From: Laura Gibbons
Sent: 06 December 2018 14:58
To: Planning.Responses
Cc: Michael Eastham
Subject: Planning Consultation on LU/345/18/DOC

Engineers Comments Regarding Condition 10

APPLICATION LU/345/18/DOC

Site Address: Land North of Toddington Lane Littlehampton BN17 7PP

Figure 3.1 Existing Lagoon and Ditch (in green) to be filled in

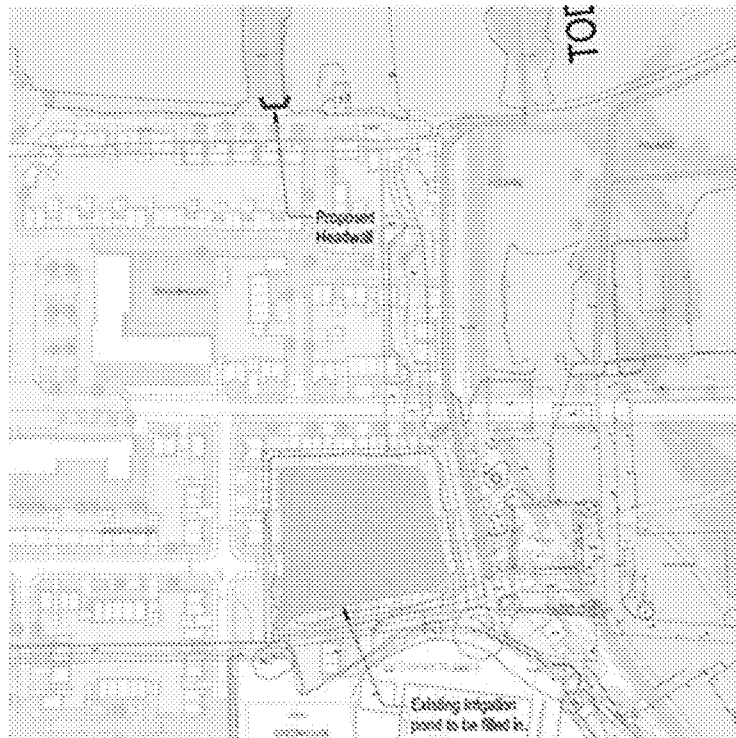
No evidence has been submitted of formal written acceptance of the proposals to infill the watercourses shown in Figure 3.1 of the drainage strategy. Therefore, I do not recommend the discharge of this condition.
